# CITY OF ALBUQUERQUE

Re: Commercial Self-Storage, Engineer's Stamp dated 5-1-07, (C18/D37G)  
Lot 30 Block 9 Tract A Unit B of North Albuquerque

# CITY OF ALBUQUERQUE

Re: Commercial Self-Storage, Lot 30 Block 9 Tract A Unit B of North Albuquerque Acres  
Engineer's Stamp dated 7-5-06 (C18/D37G)

COMMERCIAL SELF STORAGE
GRADING & DRAINAGE DETAILS

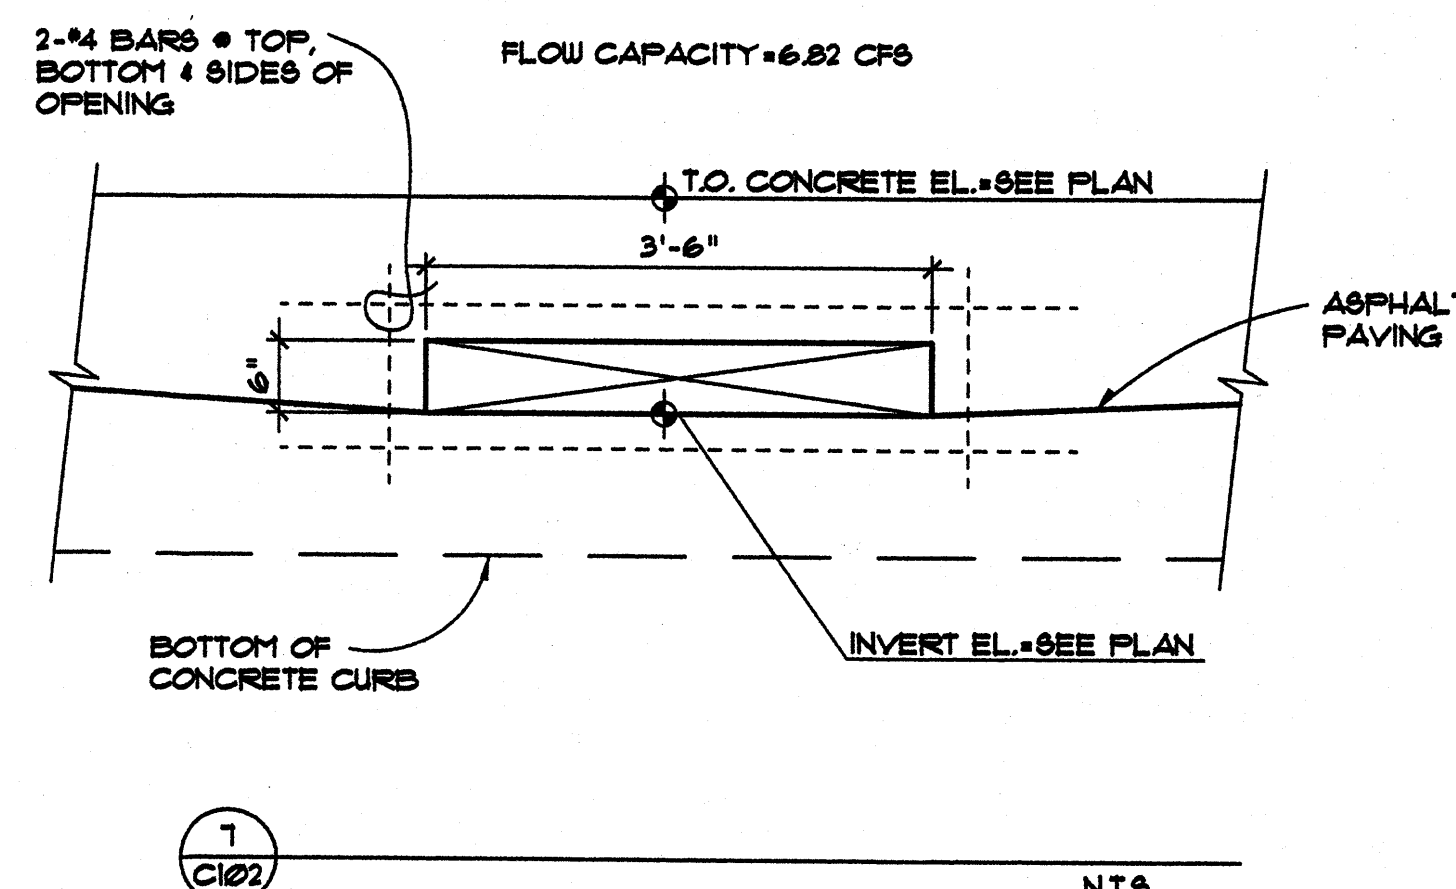
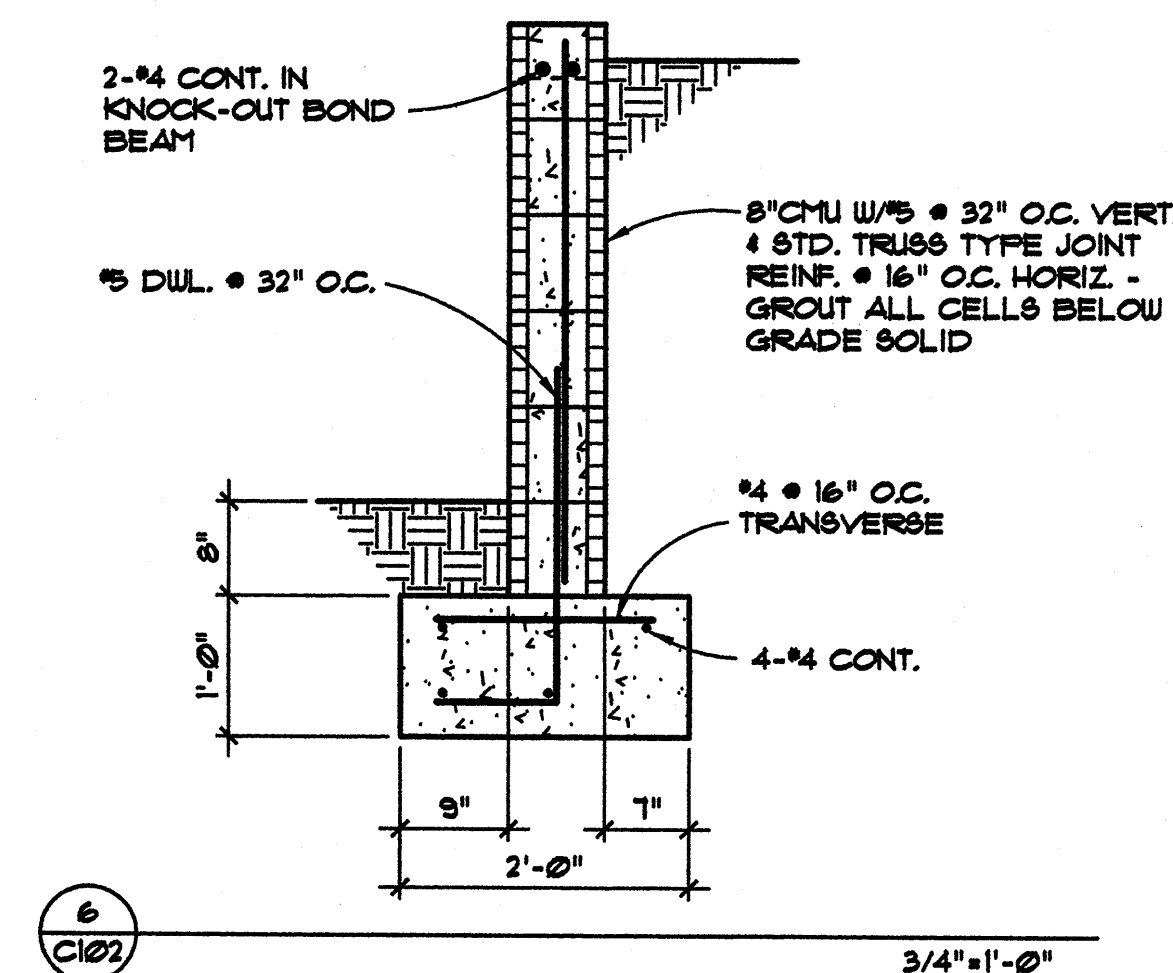
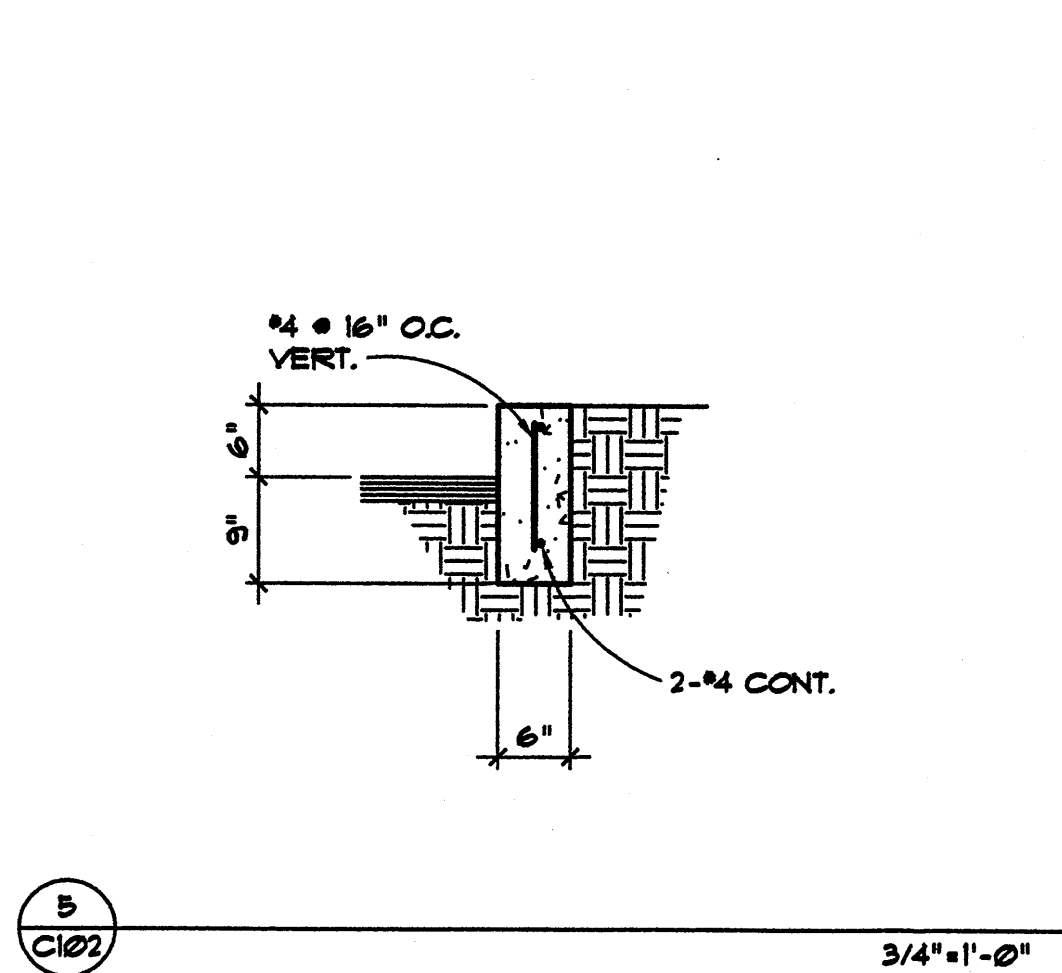
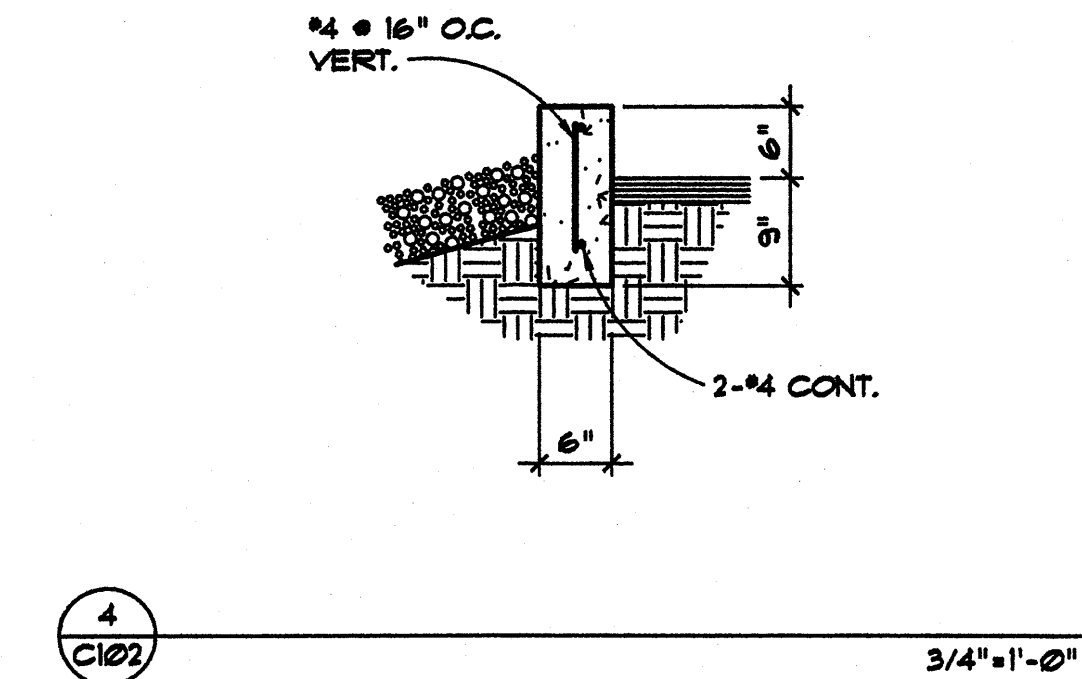
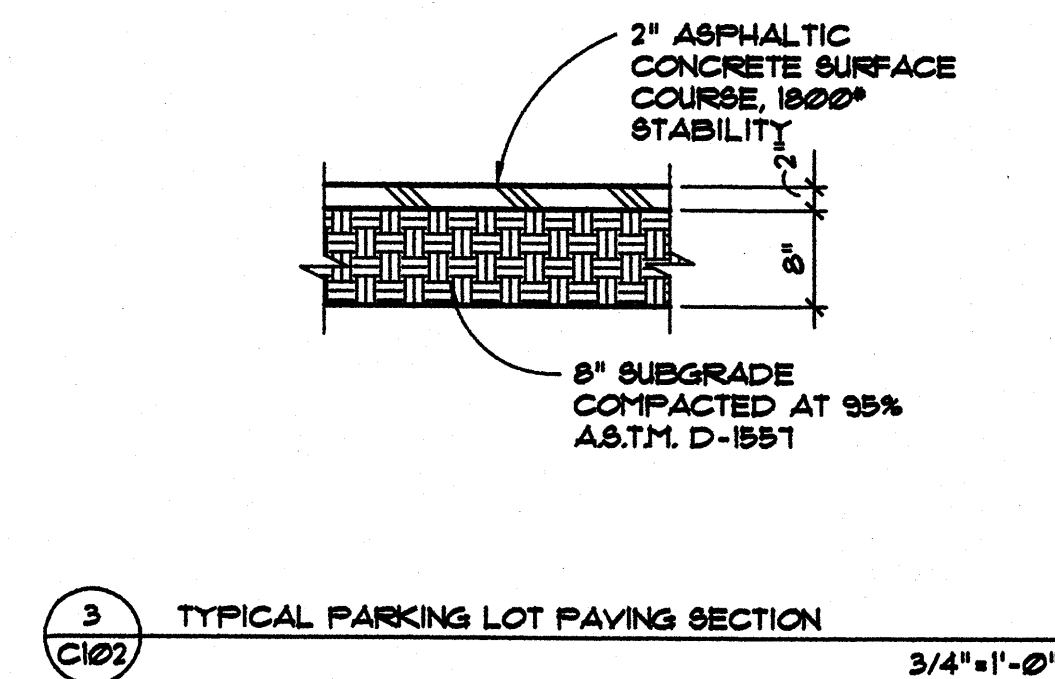
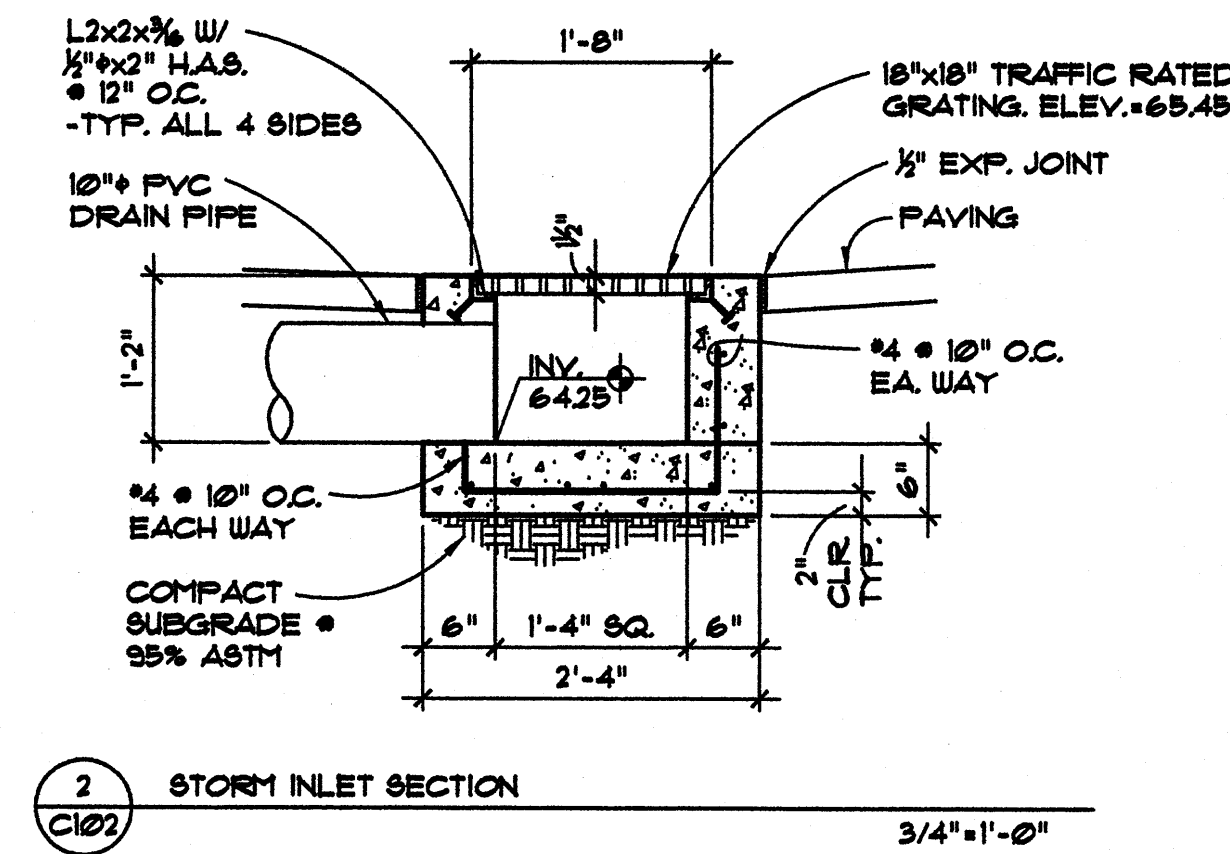
- Details 1/C101 and 2/C101 are transposed between the drawings and keyed notes.
- Please specifically reference the appropriate FIRM map panel and state that the project is or is not in a flood plain.
